98G1395

**SAPPHIRE TO WOOLGOOLGA PACIFIC HIGHWAY UPGRADE
PROPOSED AMENDMENTS TO THE CONDITION OF APPROVAL TO BIODIVERSITY
OFFSET & MITIGATION STRATEGY**

DRAWING NAME
BP22 - SW Boundary sign

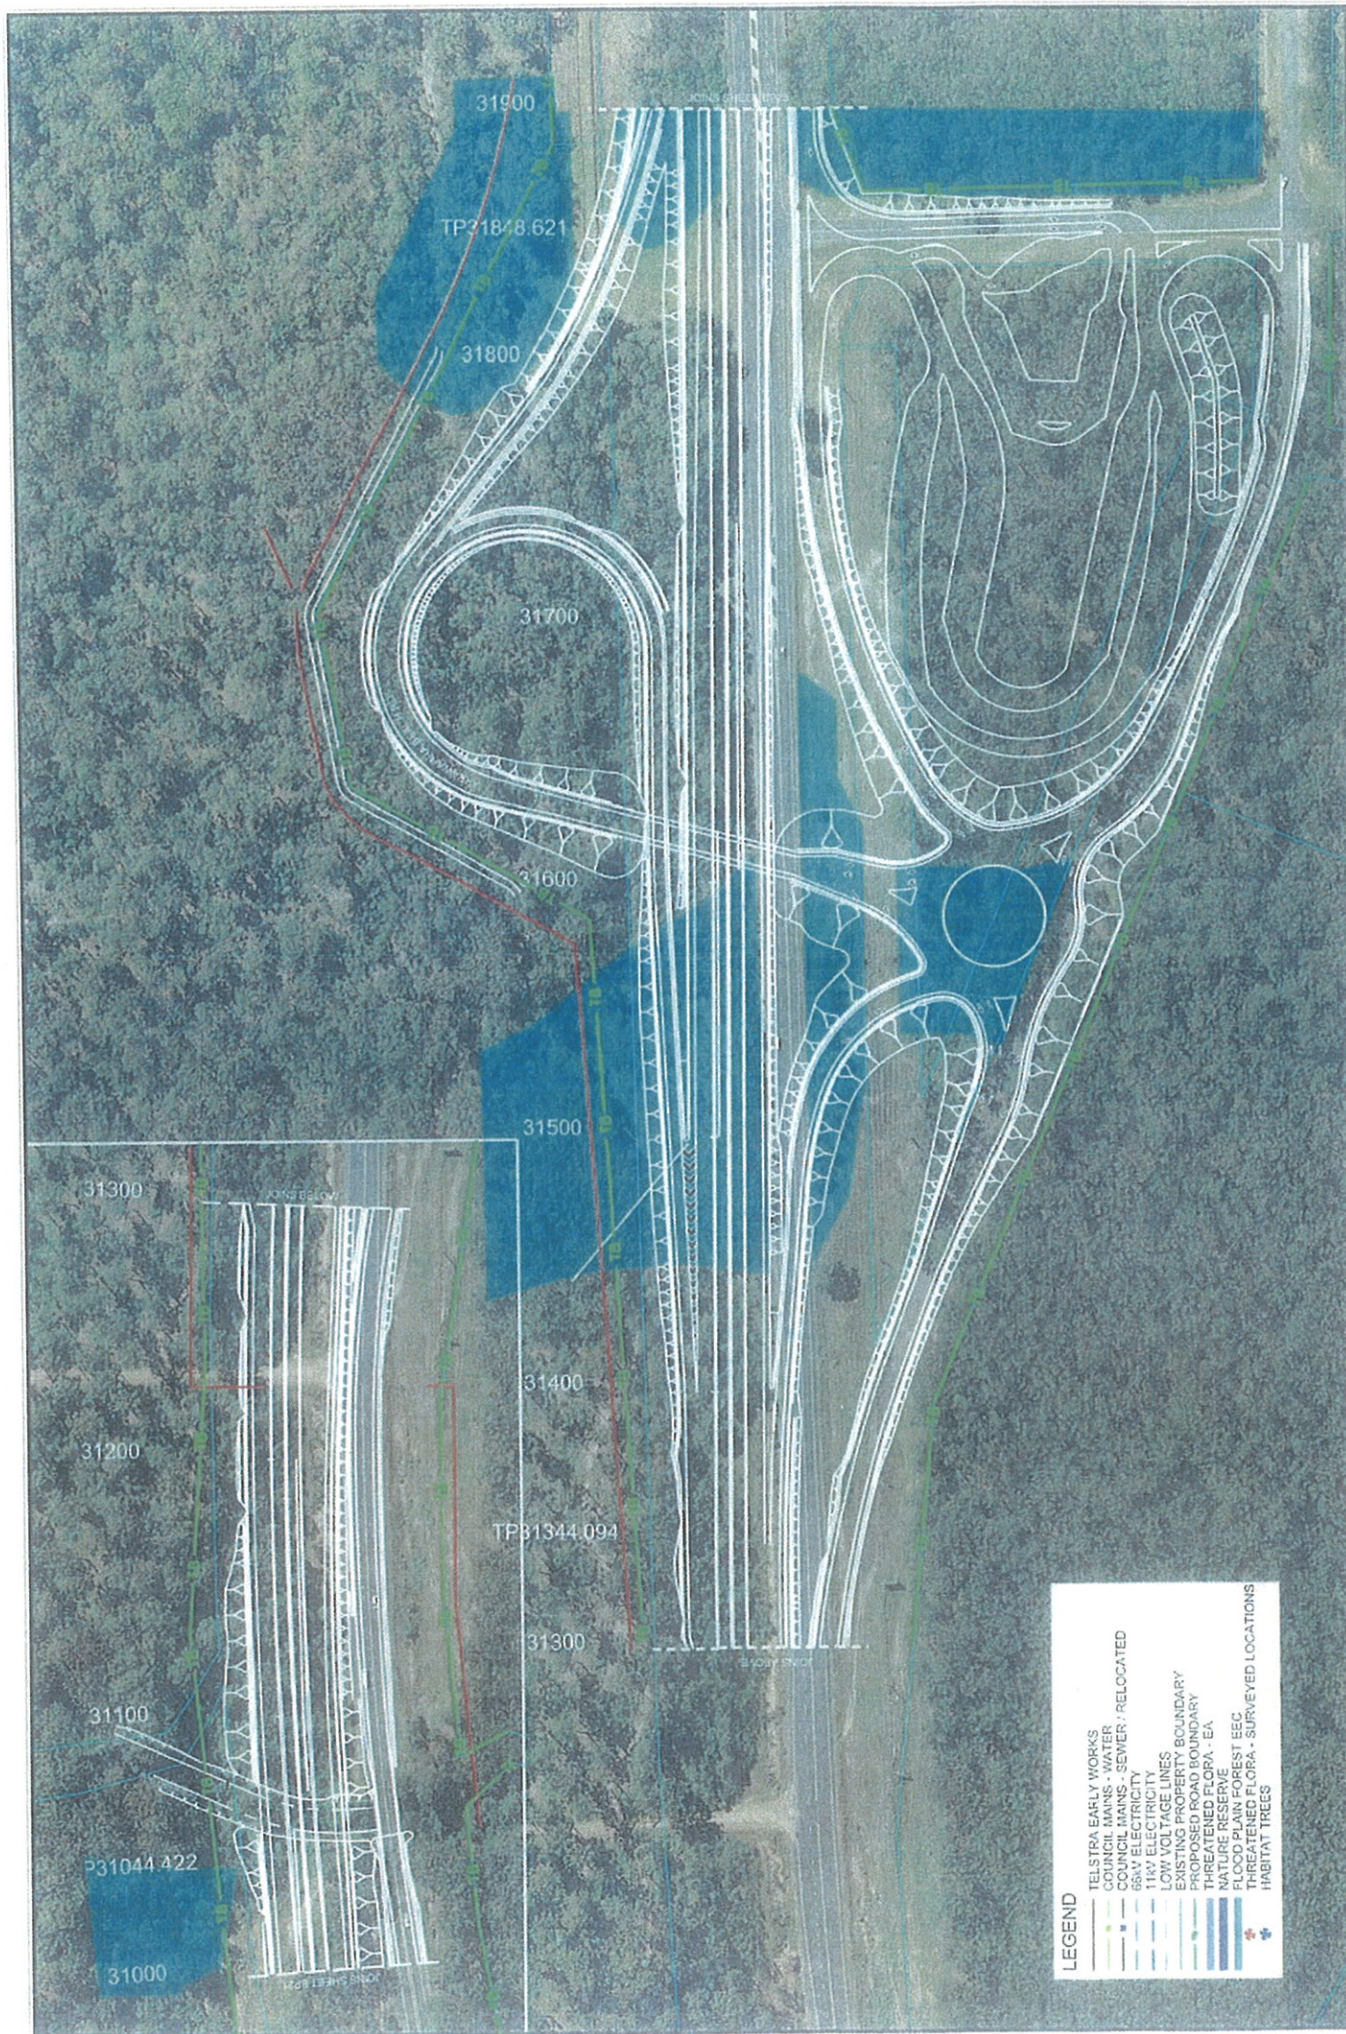
In view of the forthcoming discussions on developing offsets and to limit any impacts on the construction programme, the RTA is seeking an amendment to the condition of approval to allow the minor clearing of ECC. Specifically, it would enable the clearing of 1.44 hectares of ECC associated with the utility relocation works for Sapphire to Woolgoolga. DECCW has indicated in-principle support for this amendment and I understand has written to you separately in support of this approach. Details of the nature and extend of clearing in ECC are provided in Attachment A.

The utility relocations involve the clearing of a total 1.44 hectares of Coastal Floodplain Forest-Broad Leaved Paperbark an Endangered Ecological Community (EEC) listed under the NSW Threatened Species Conservation Act. The table below shows the breakdown of the clearing of EEC by utility relocation type.

Figures on BP09, BP10, BP11 and BP 22 below detail the location of the utility relocation works in relation the mapped EEC.

Mitigation Measures to reduce impacts of native vegetation, including EEC to be implemented via an Environmental Management Plan include:

- Where vegetation removal is required it is to be strictly controlled and clearing would be restricted to the minimum area required to undertake the works.

- The limits of vegetation clearing disturbance will be signposted clearly, delineated on site and recorded on work plans prior to clearing
- No service relocation works (including storage of plant, equipment, materials) or access by unauthorised personnel is permitted in native vegetation areas outside of the flagged works footprint.
